City of Albuquerque Stormwater Construction Site Inspection Report

Project Name:		Defined Fitness @ Unser Crossings					
Location:		Unser & Central					
Site Contact Name & Agency	Joseph - Blanchard Properties			ESC File No.	K10E045B		
	rjones@jonescpa.com			NPDES Id. No.	NMR1001X7		
Inspection Date:	06/04/19	Start/End Time:	0750/0830hrs				
CoA Stormwater Inspector:		Timothy E. Sims					
Construction Phase:		foundation and plumbing					
Type of Inspection:		Regular	Storm Event	Post Storm Event >0.25"	311/Complaint	x	Follow Up

SILT FENCE FOR SEDIMENT CONTROL

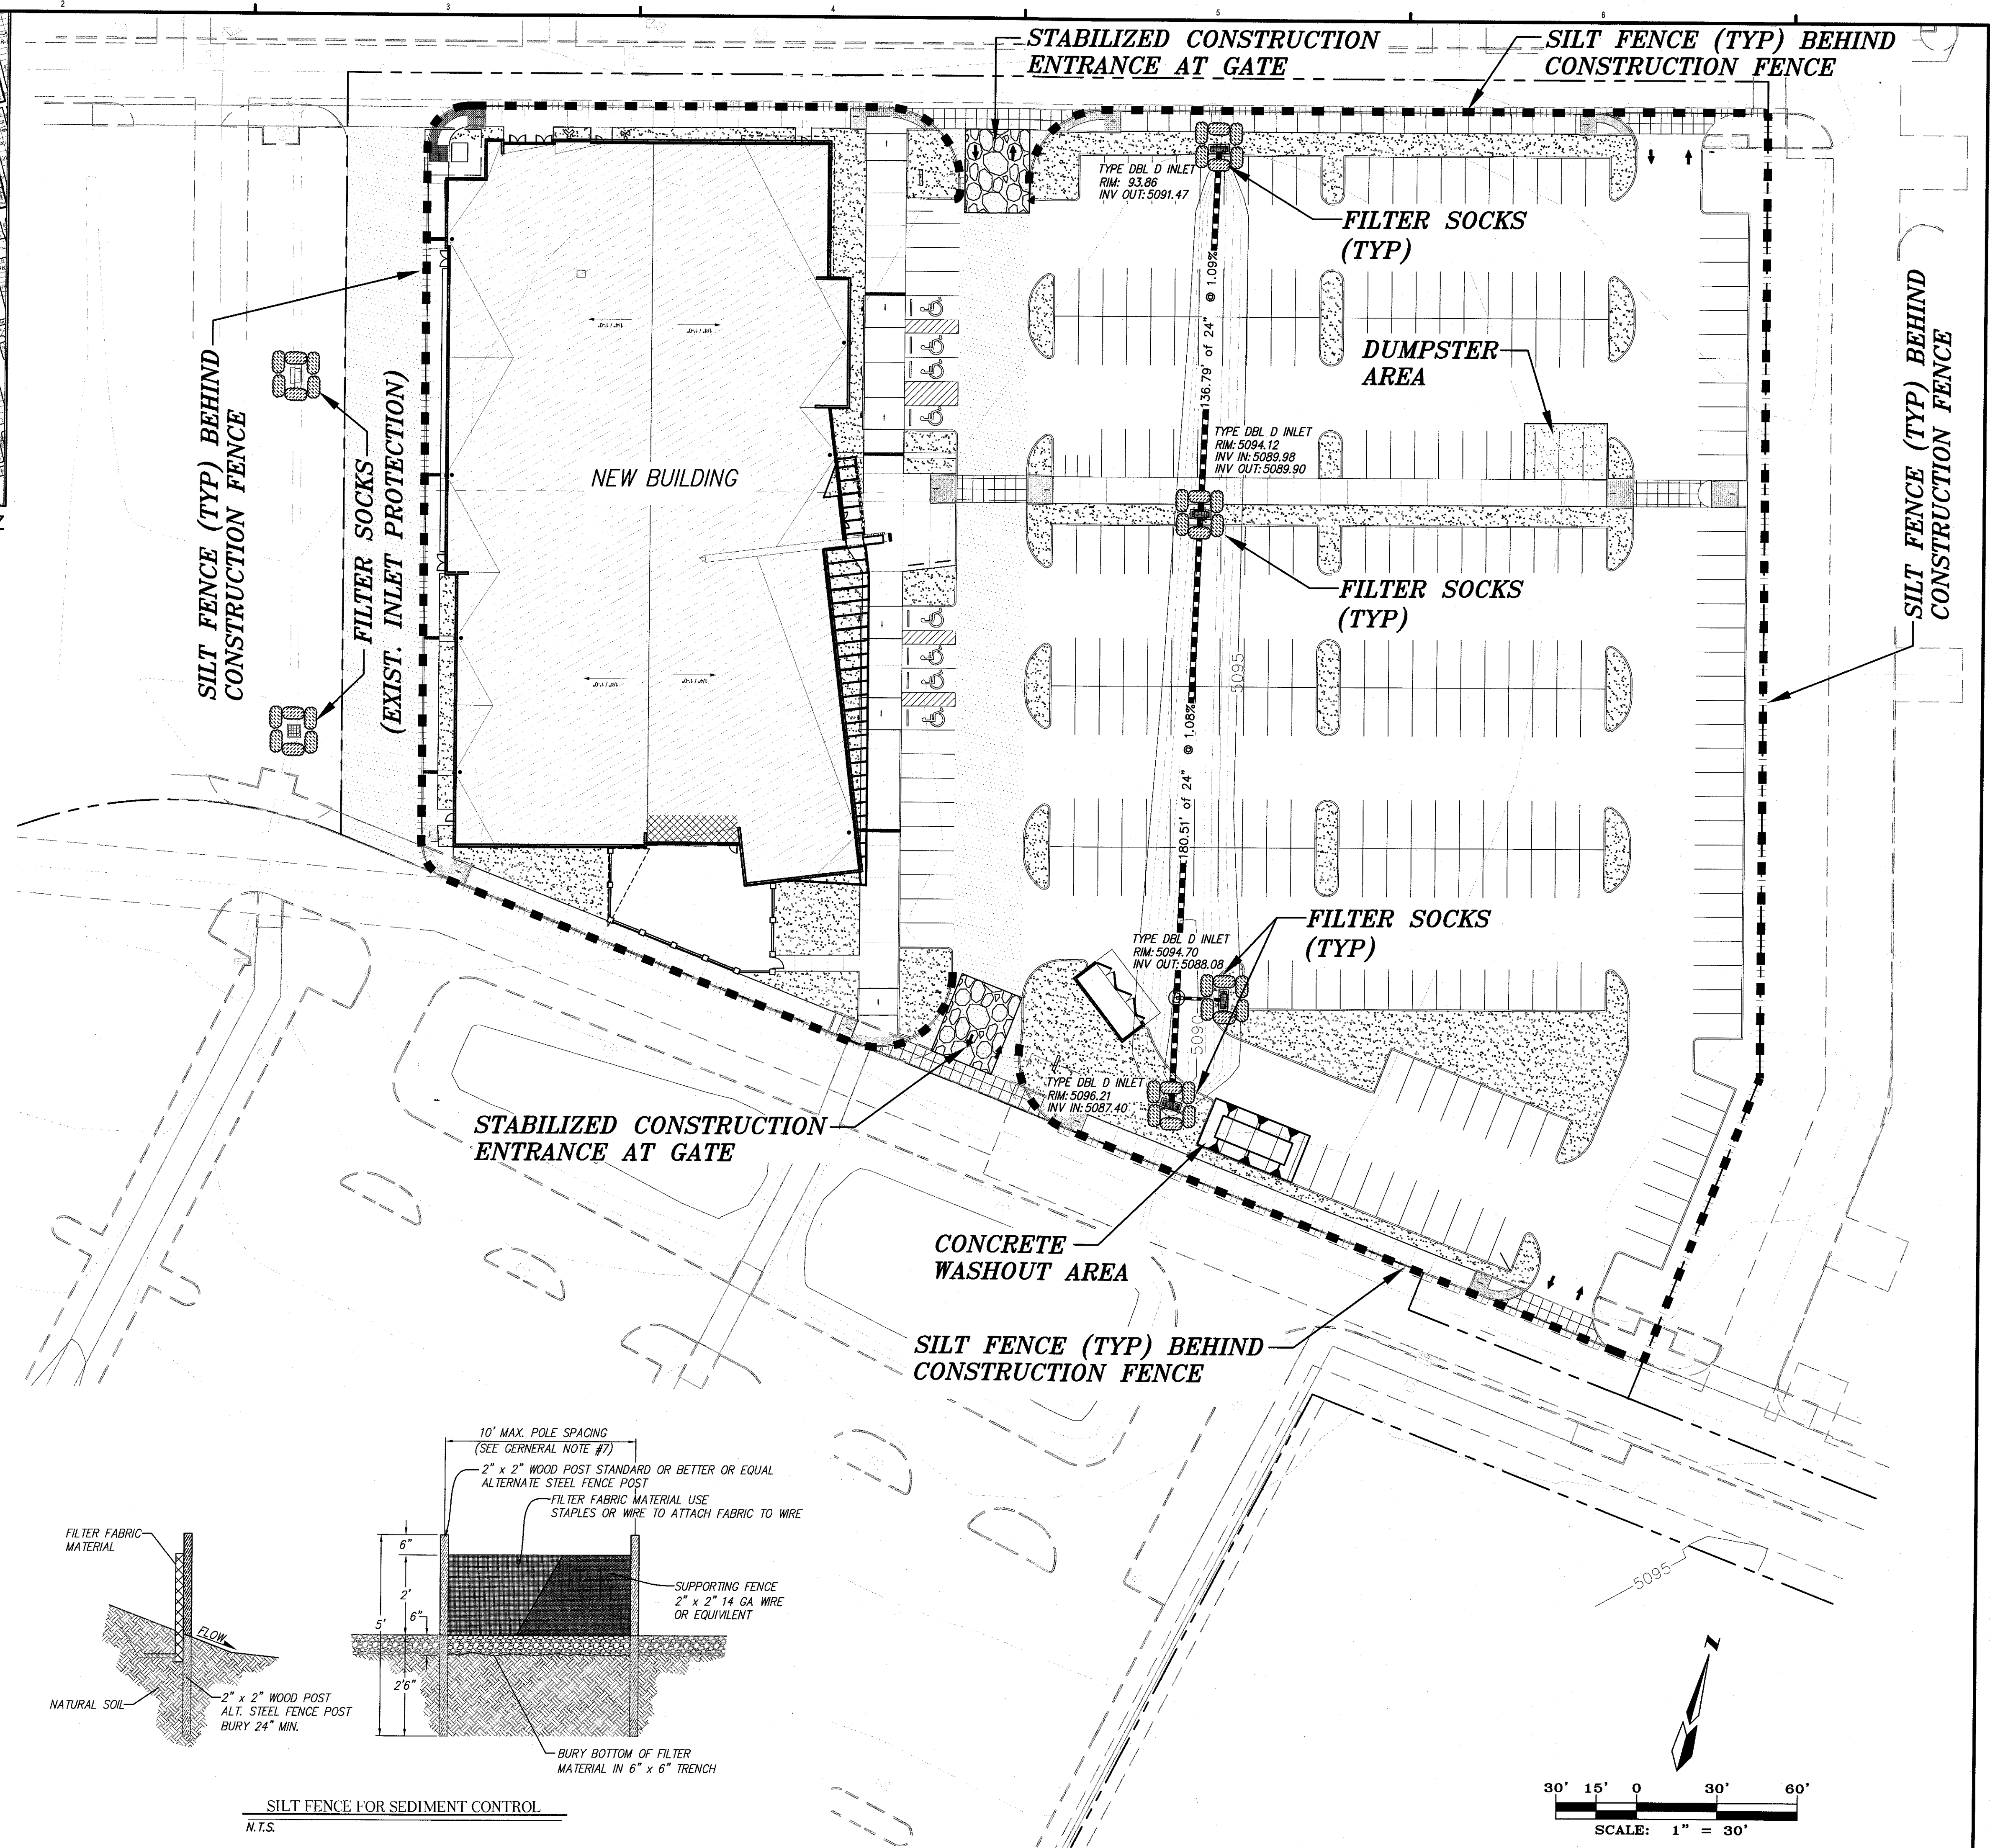
Item Number	Deficiency/ Corrective Action		
1	Please provide the latest self-inspection report		
2	Perimeter silt fence require maintenance. Sediment build up exceeds 50% in some areas and some sections are down. Please re-install and remove sediment in these areas.		
3	This mornings washout from concrete pumping requires cleaning.		
4	concrete washout facility requires maintenance. It if full.		
2.1	Discharge off site? (Y/N)	No	
4	Self Inspection Reports	requested	Latest report Date:
